Our Case Number: ABP-318802-24
Planning Authority Reference Number:

Re: Proposed development of a resource recovery centre (including waste-to-energy facility)
in Ringaskiddy, County Cork.

12th November 2025

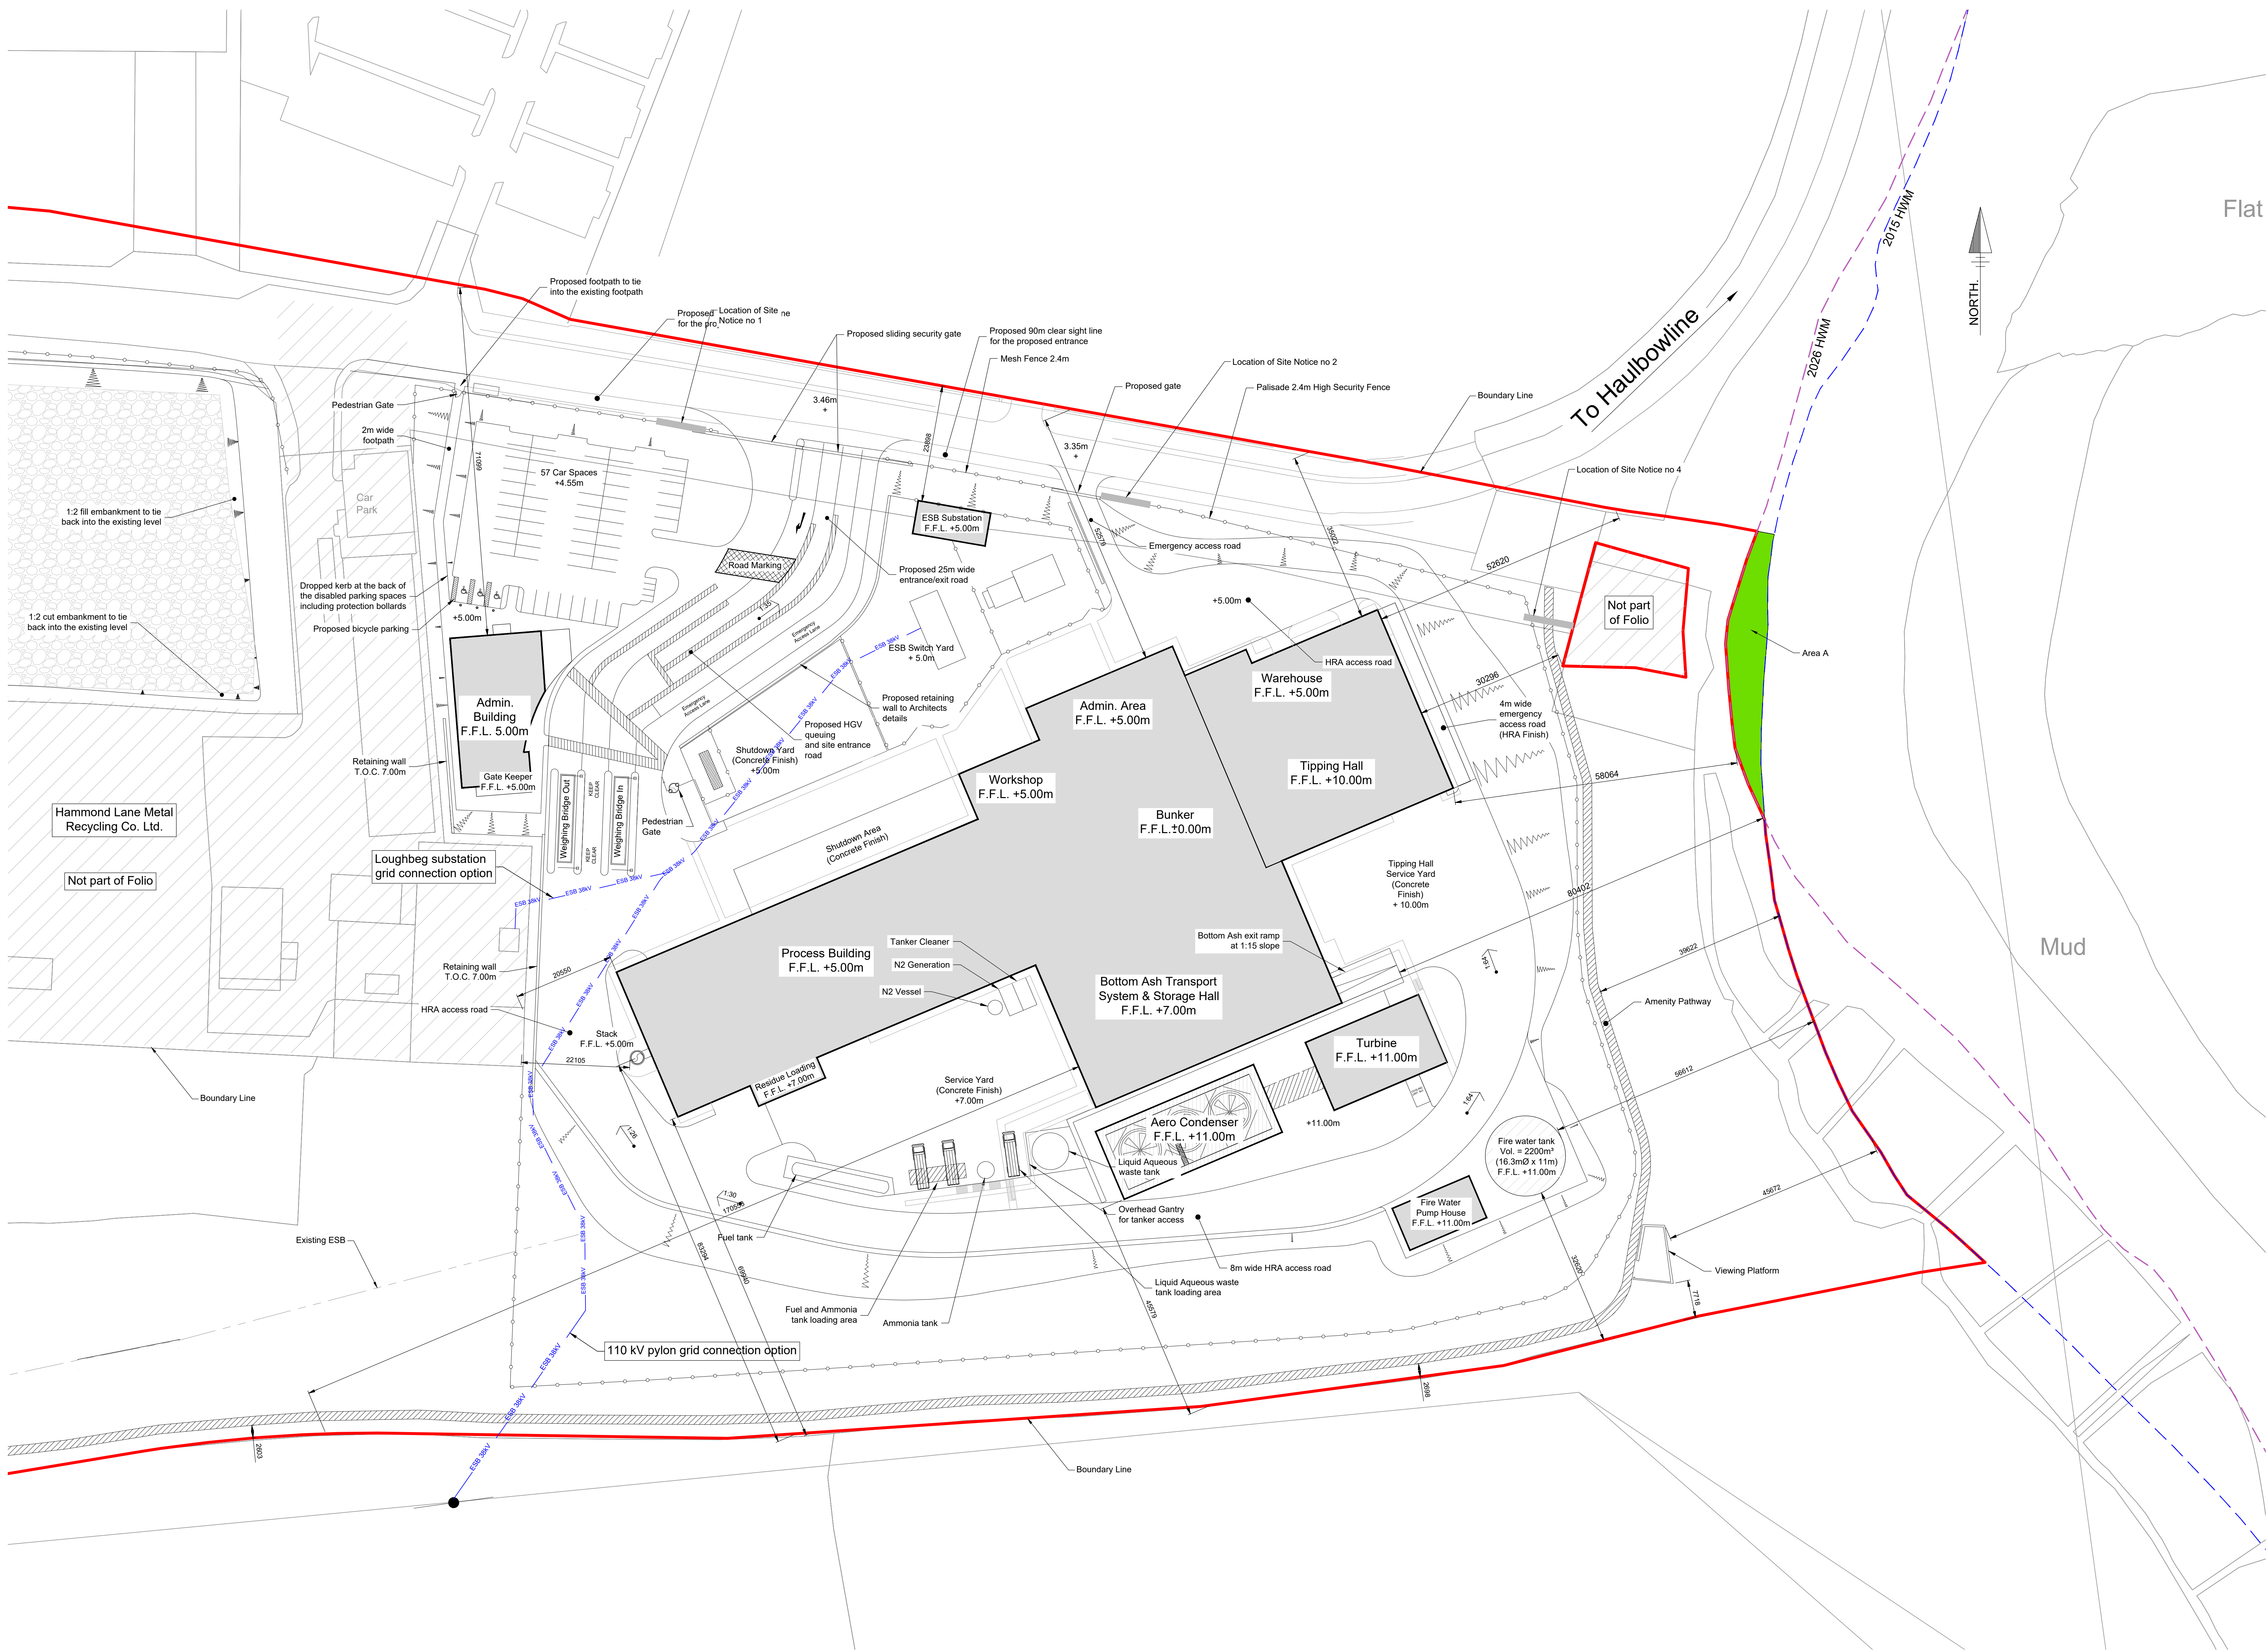
The plans, as submitted, are invalid as the drawings do not take into account the new road that is nearing completion. It is unclear what impact the construction would have on the newly constructed road without up to date drawings. Indeed, according to the crude drawing over a Google Maps satellite view of the site in Figure 1 of the Planning Report, it suggests the site extends into the soon to be opened road. It should be confirmed if the applicants has permission to use Google copyright material in their application.

The plans do not indicate how the area denoted as Not part of Folio is to be incorporated into the overall site setting. The architectural drawings omit the building and chimney stack profiles.
